DEVELOPMENT FACILITATION TEAM
SUPPLEMENTAL SUBMITTAL

PROJECT NO. 2023-009688
Application No. SI-2024-00597

Attn. : DFT Chair
Cc. : Reviewers
Re. : **SI-2024-00597 – SITE PLAN DFT**
 : **2026 Central SW**
Project No. : **PR-2023-009688**

The architect has been advised by the City that this information is for informational use only and is not to be used for any other purpose.

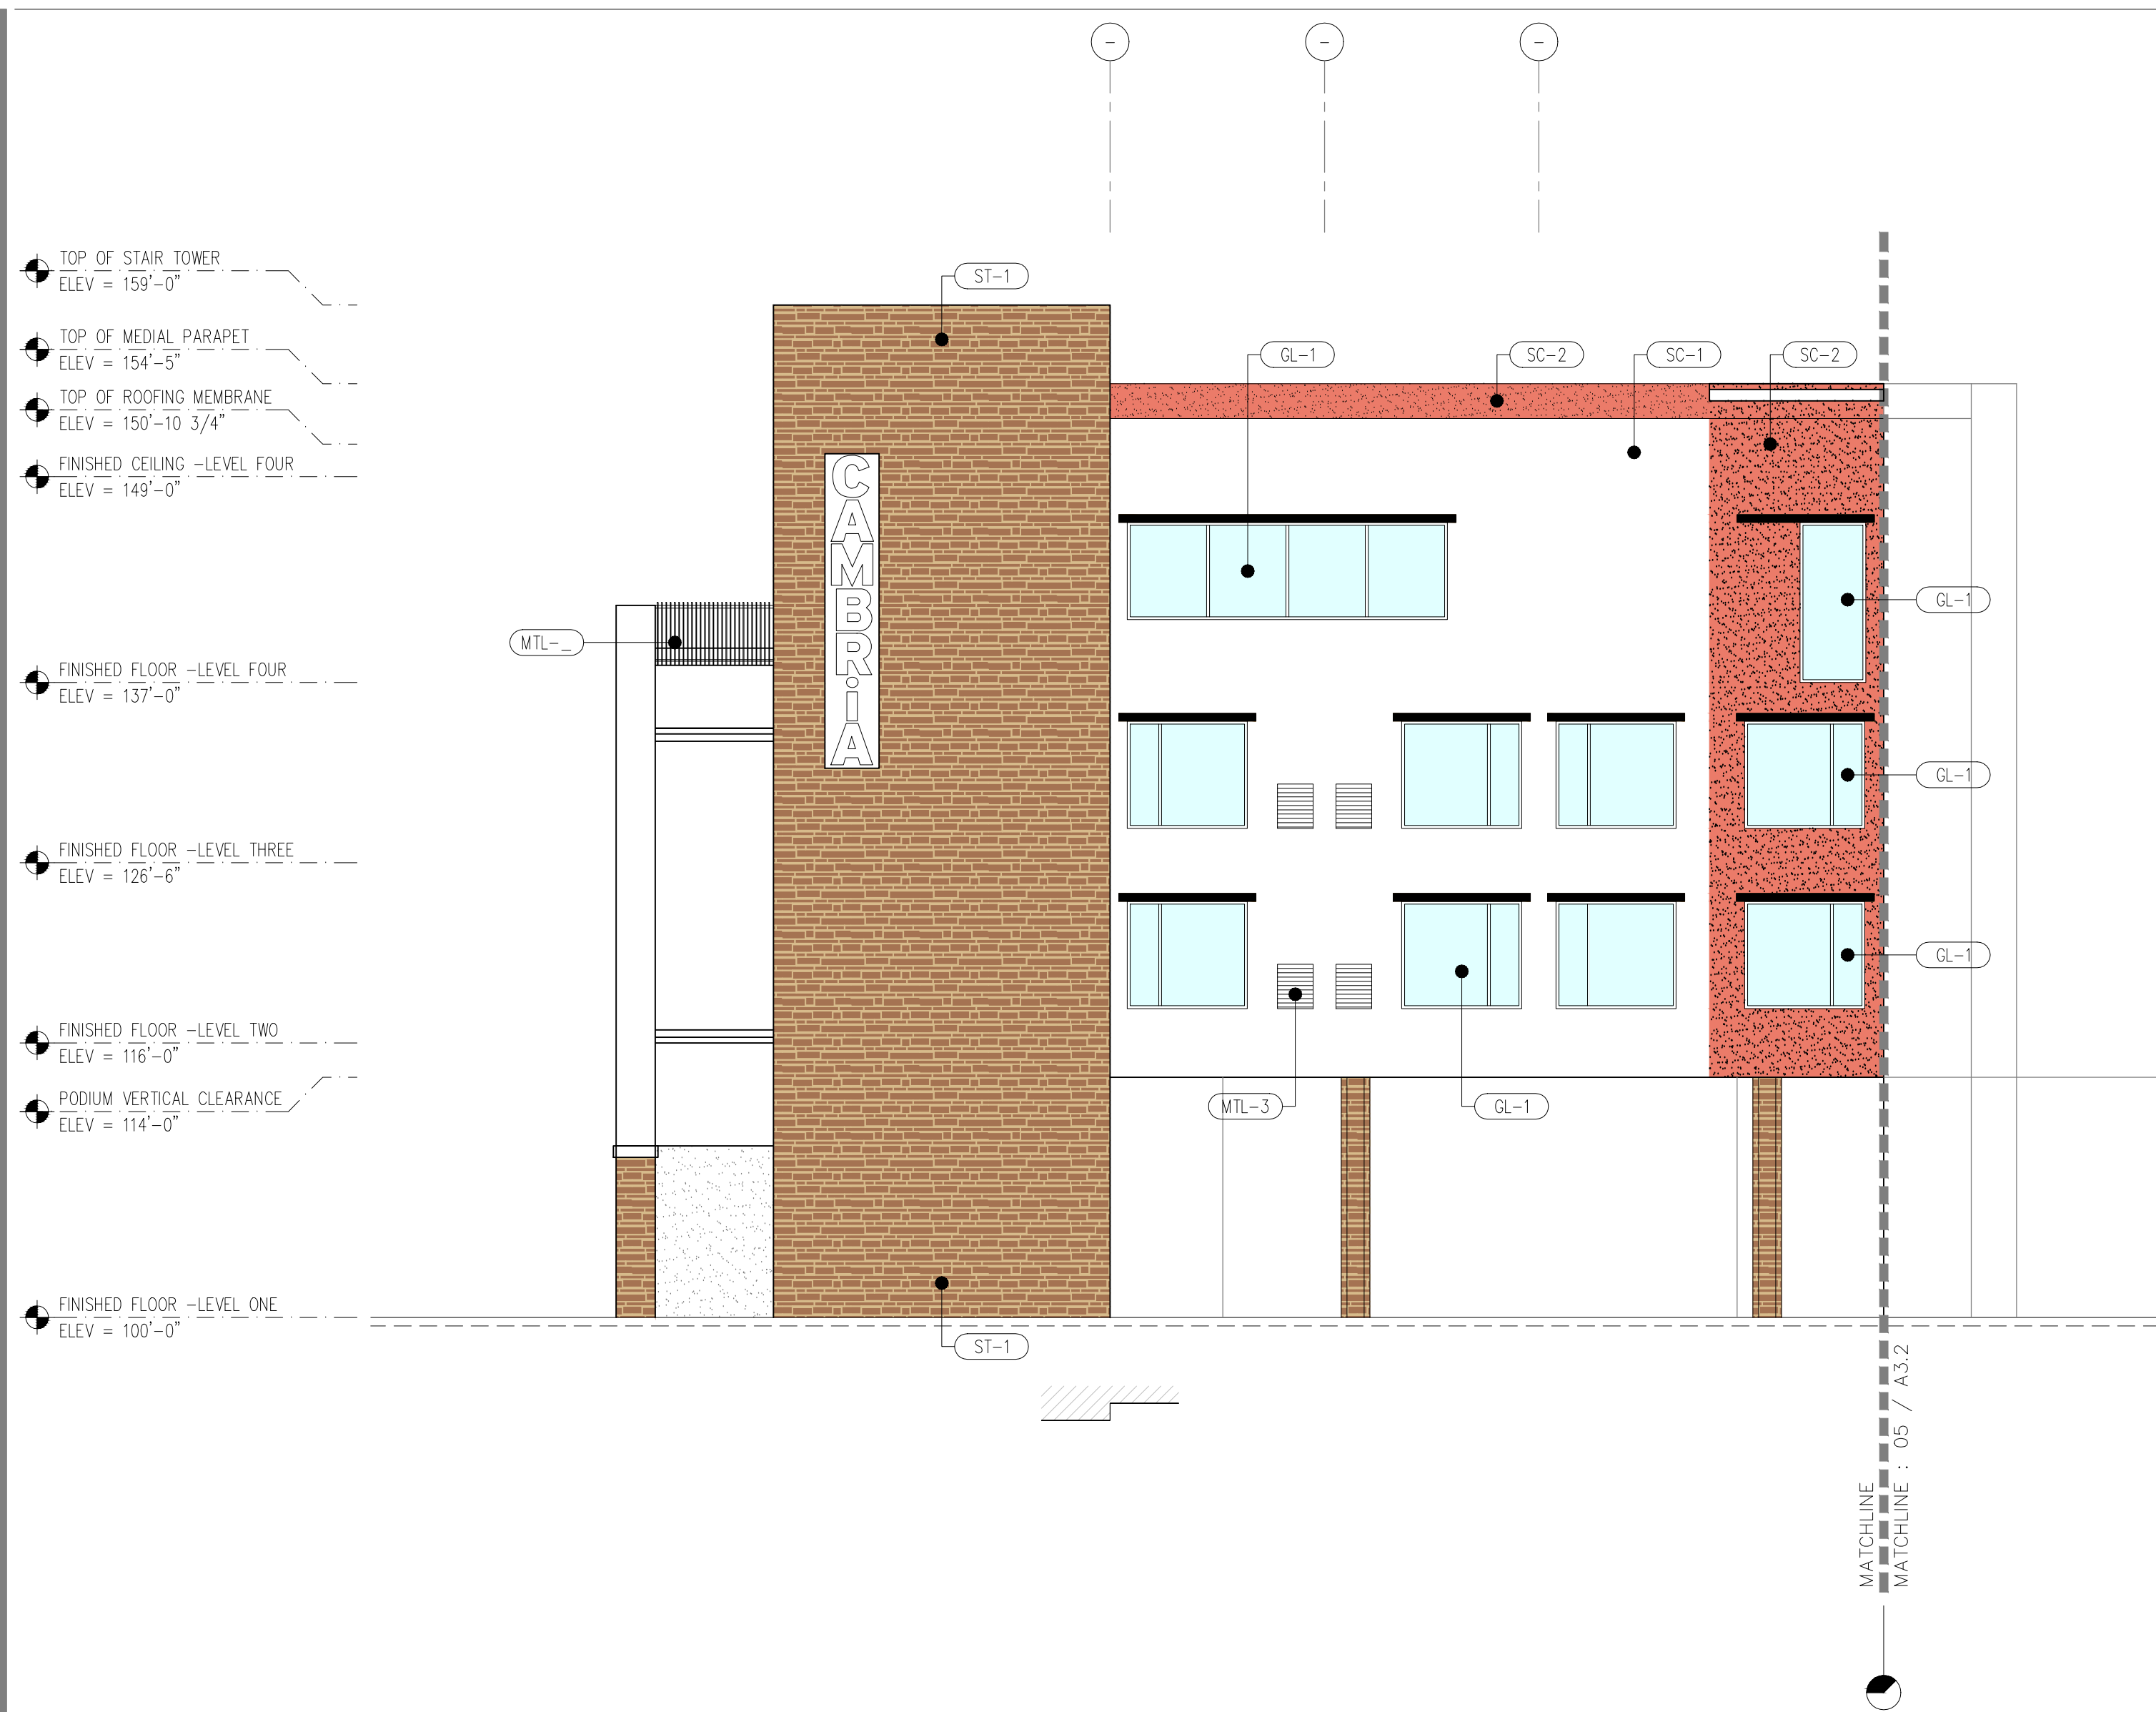
12 **Comment** - 5-5(G)(3)(b) No horizontal length of any façade shall extend longer than 40 feet without the inclusion of architectural elements such as decorative grillwork, louvers, translucent screens, alternating building materials, projection of lintels, portals, and other external features to avoid visual monotony. A change in color alone does not satisfy this requirement. Confirm compliance.

Response: Concur. The elevations have some lintels shown, but we have added some other architectural elements in the stretches of elevation that are more than 40' to avoid visual monotony.

01 ENLARGED FRONTYARD SITE AREA

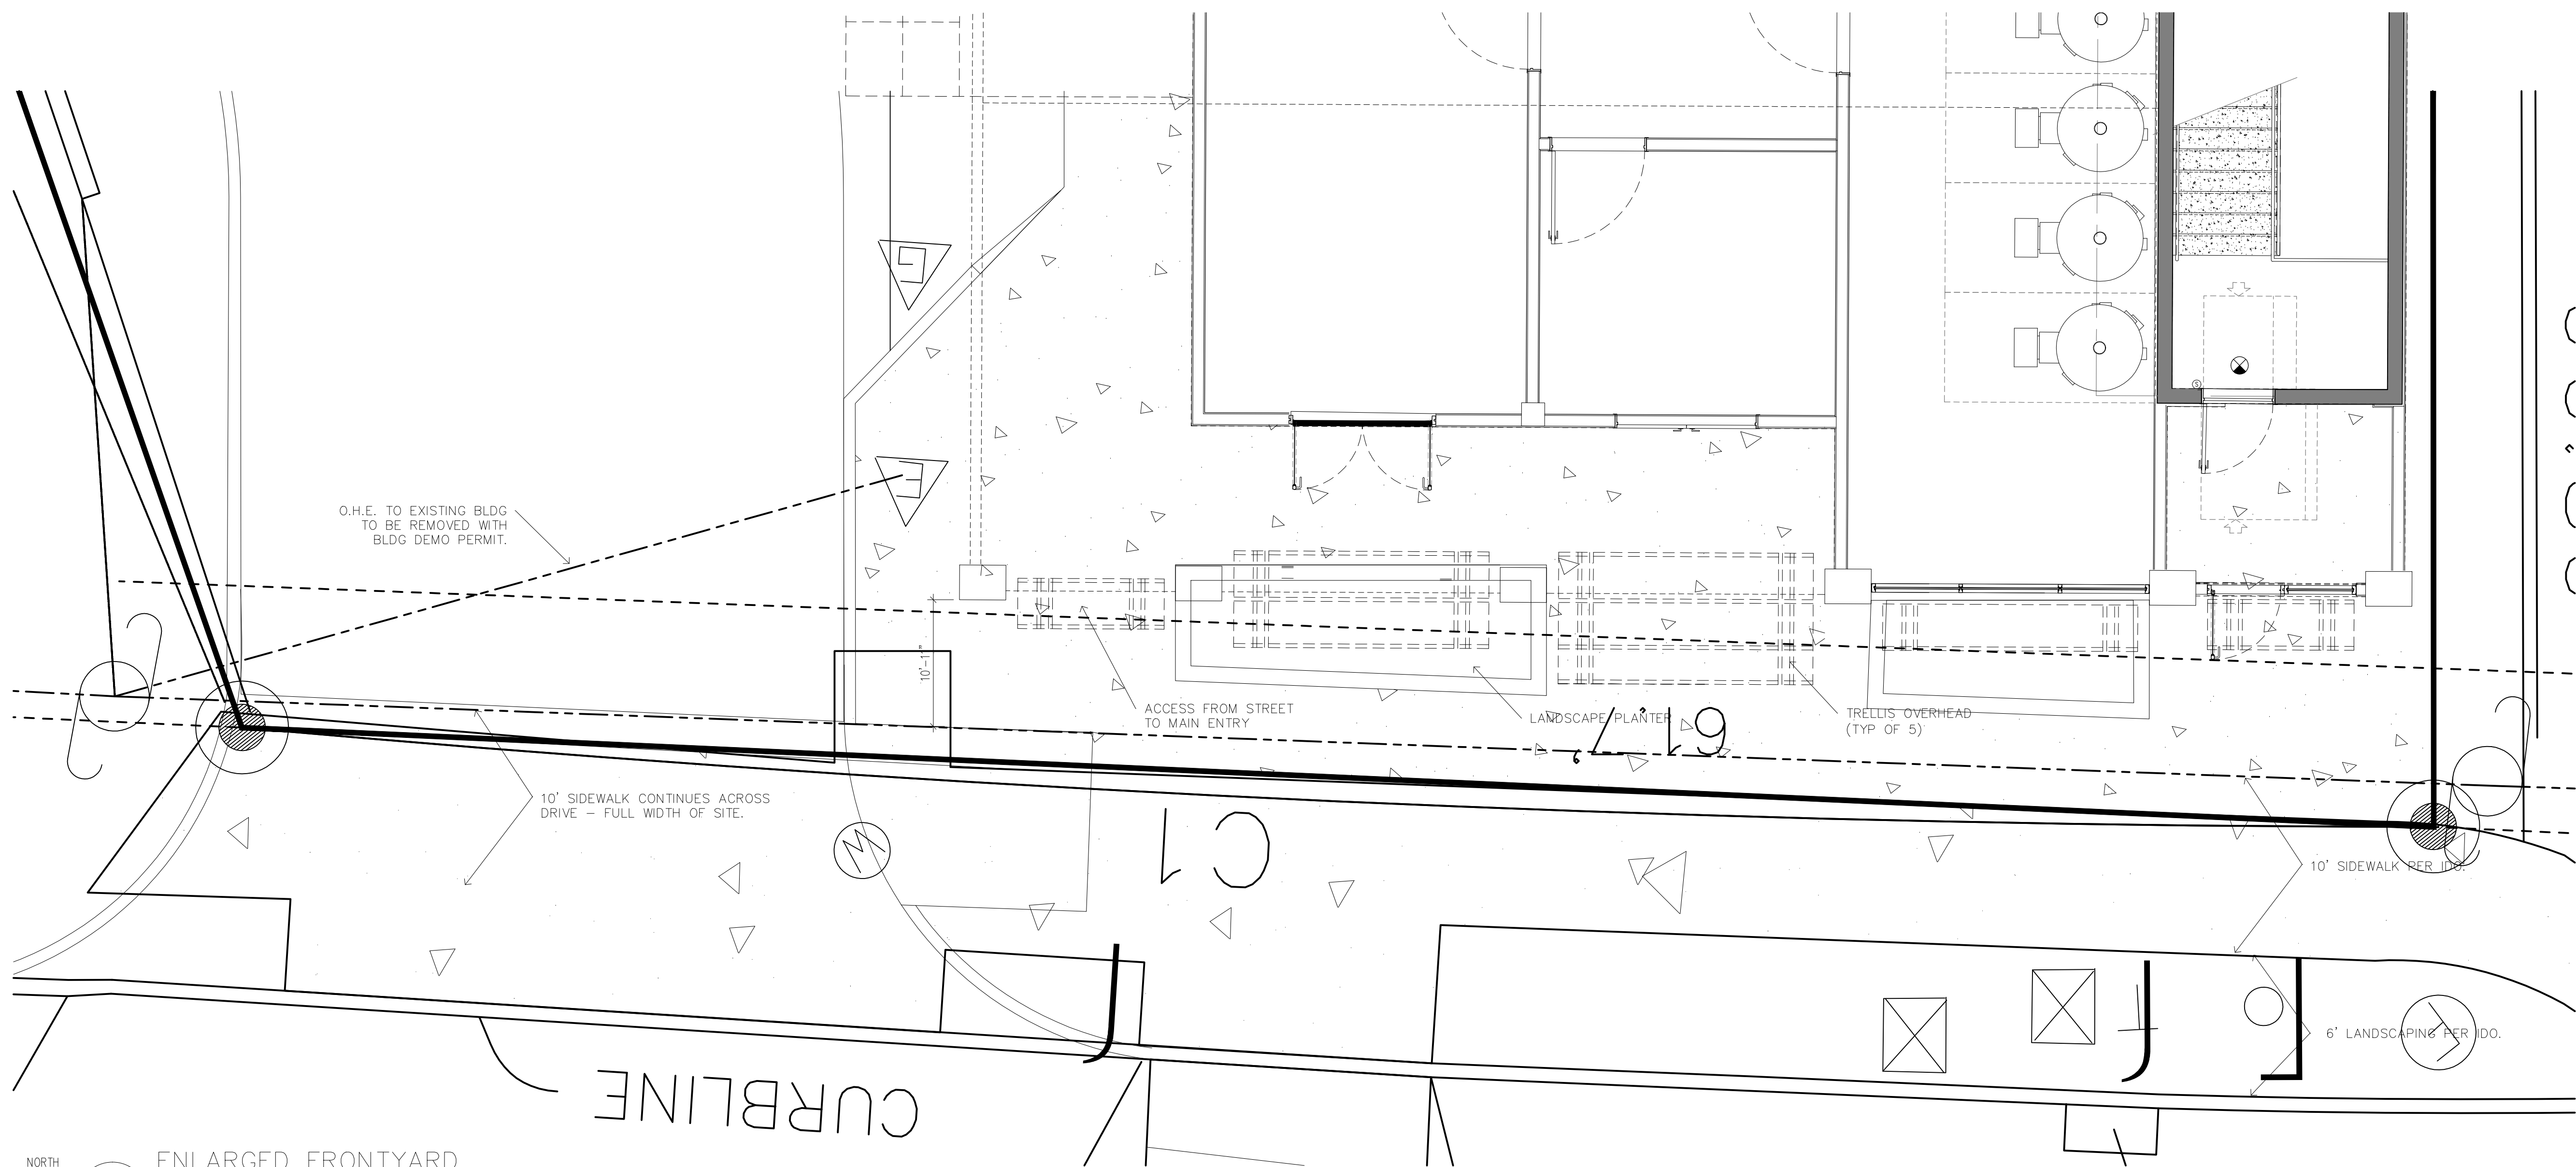
3 **Comment** -Please show calculations and/or measurements on site plan to show how you are meeting unique requirements for Urban Center, Main Street and Premium Transit Areas, IDO 5-1(D)(2), regarding (a) setback in relation to sidewalk width and (b) percent of front property line occupied by front building (see excerpt in notes, below).

8 **Comment** - IDO 5-3(D)(2)(b) Reference DPM 7.2.29 for Sidewalk/landscape buffer widths. Parcel is outside of a Center. This location on Central is within a Premium Transit Station Area, a Major Transit Corridor, and a Main Street Corridor. Therefore, Central requires an 8–10-foot sidewalk and a 6–8-foot landscape buffer. Provide widths of existing features on the landscape plan to match the site plan and show street trees in the landscape buffer.

Response: An enlarged area plan has been provided that illustrated the manner in which the project meets the unique requirements for UC, MS and PT Areas, IDO 5-1(D)(2), regarding (a) Setback in relation to sidewalk width and (b) percent of front property line occupied by front building.

Response: An enlarged area plan has been provided that illustrated the existing features at the front property line that coordinates with the landscaped plan.

01 SITE DEVELOPMENT PLAN
SCALE: 1" = 30'-0"

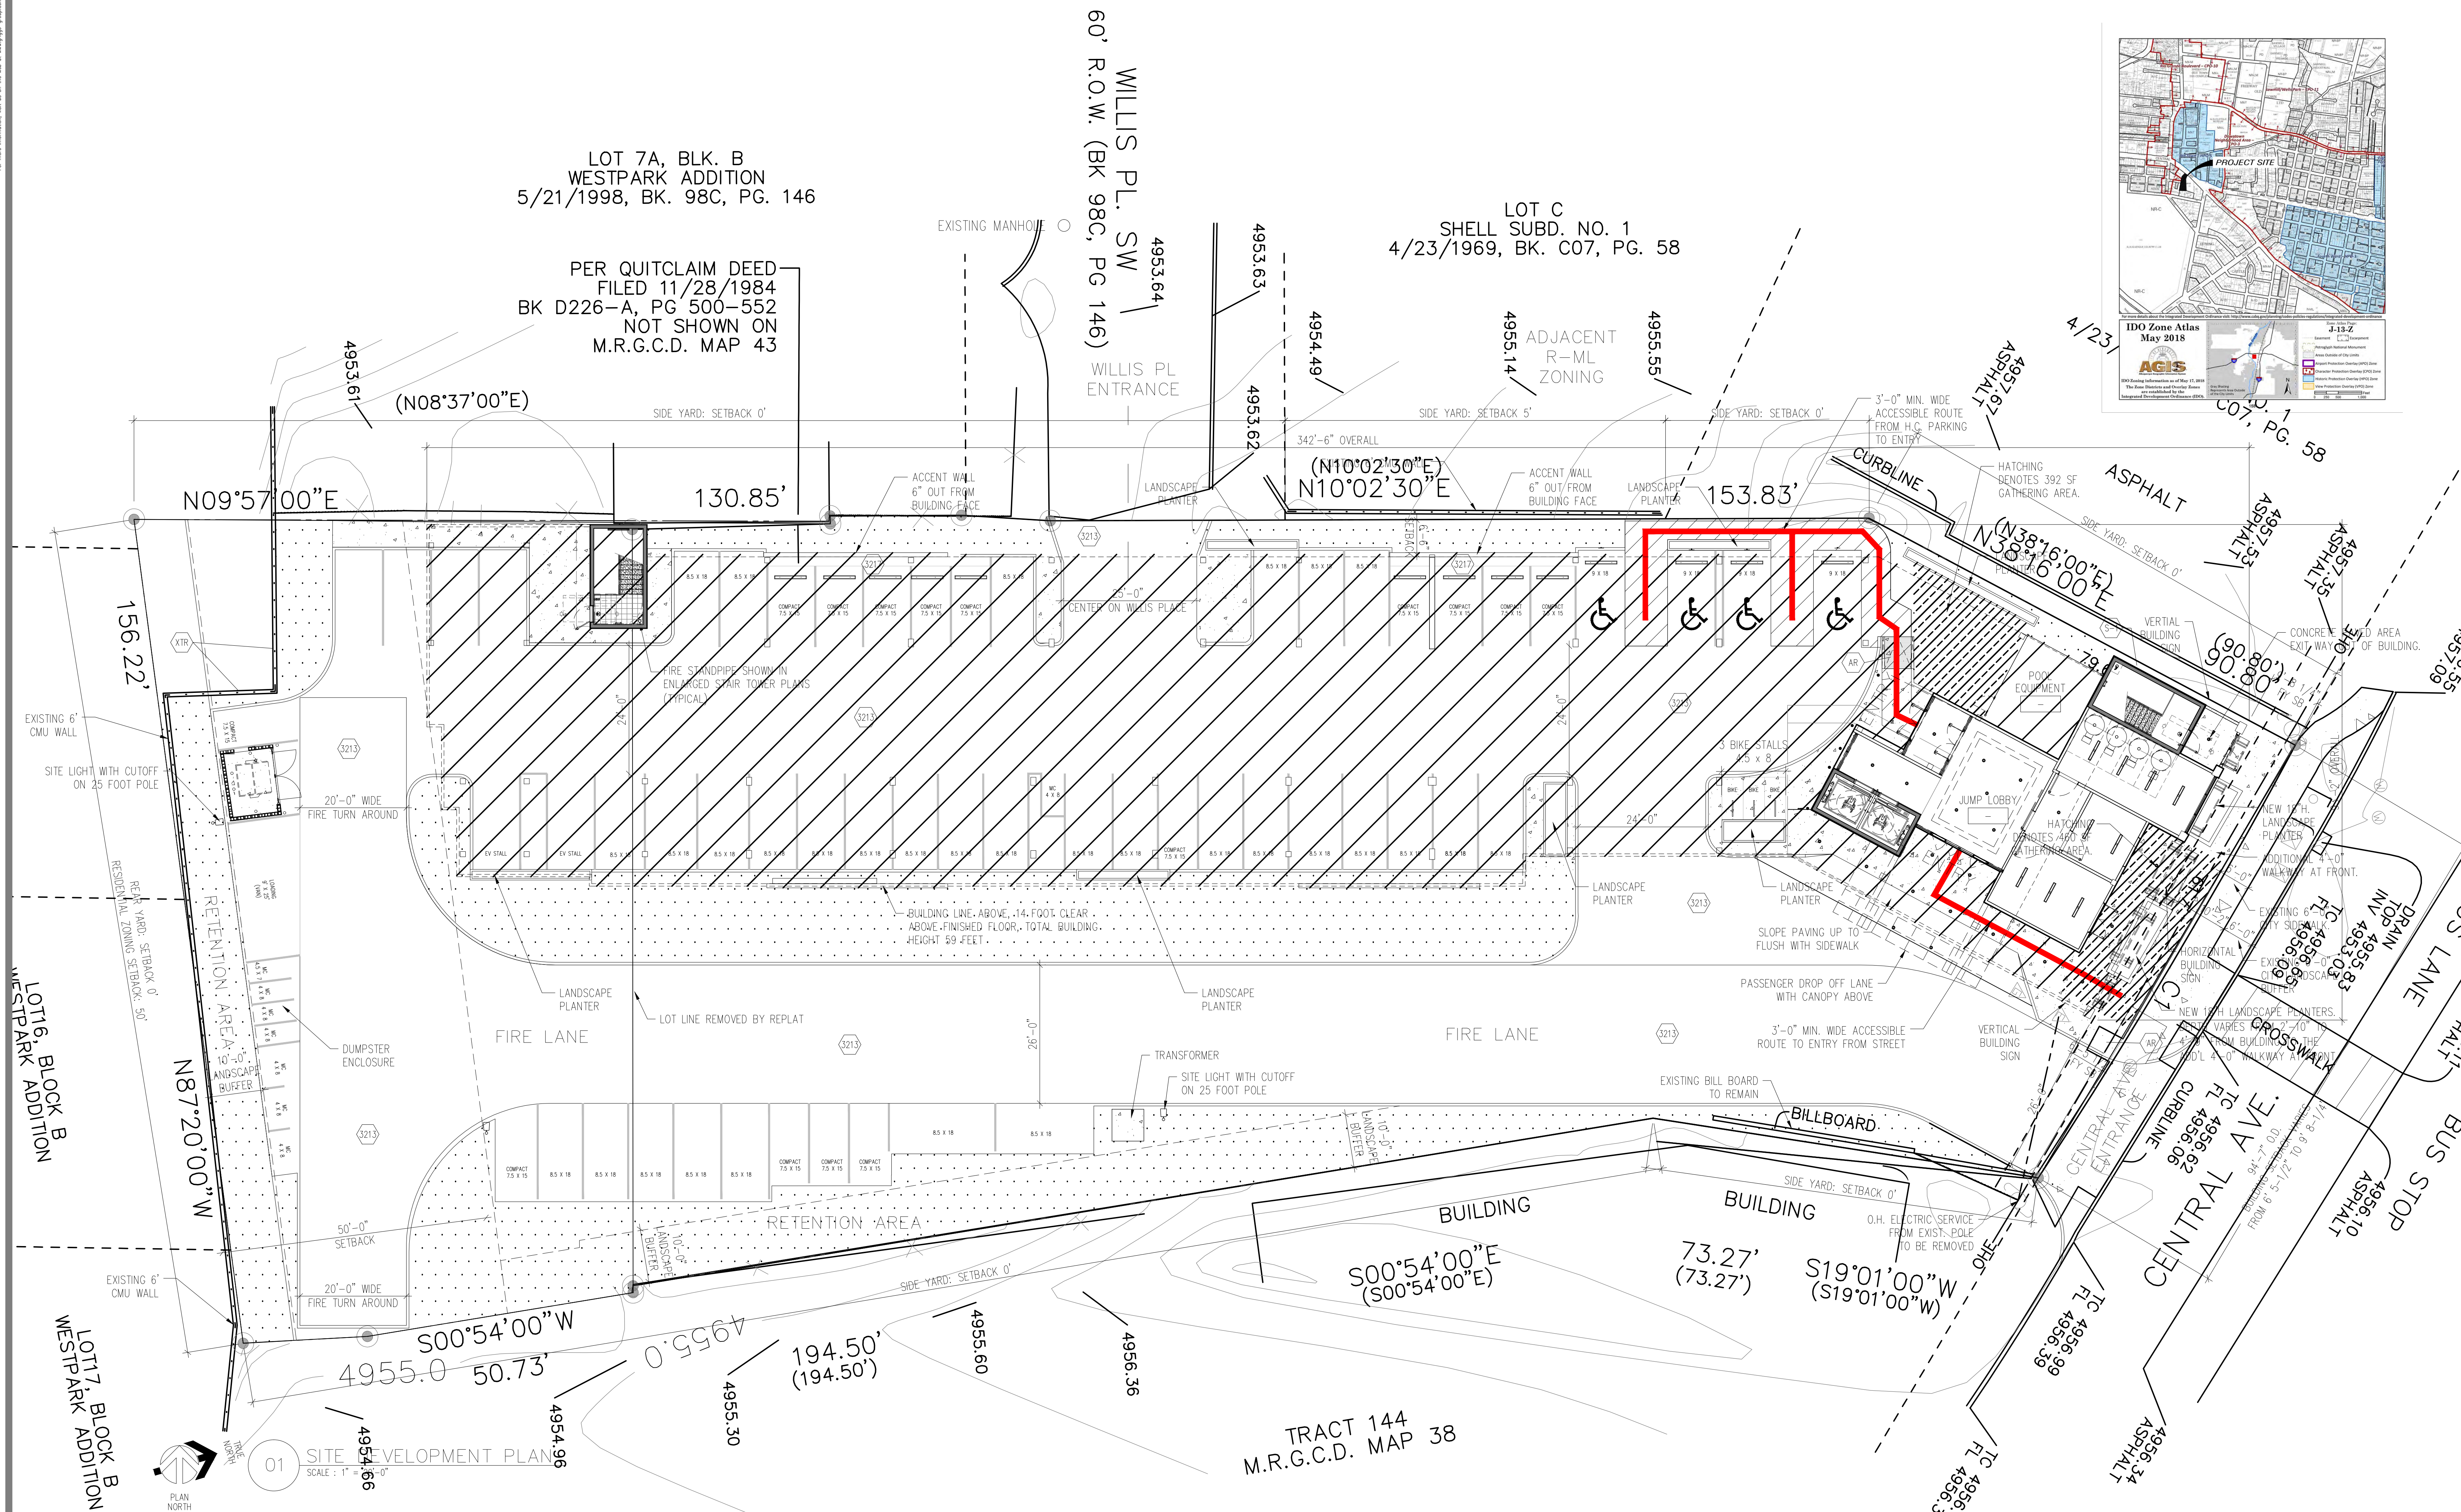
2 **Comment** - Must meet Dimensional Standards as per IDO 5-1(D), Table 5-1-2. Please show setbacks more clearly on the Site Plan.

1 **Comment** - Project and Application numbers must be added to the Site Plan.

Response: Plan has been revised to show the dimensions of the setbacks on all sides.

Response: The Application Number has also been added to the plans.
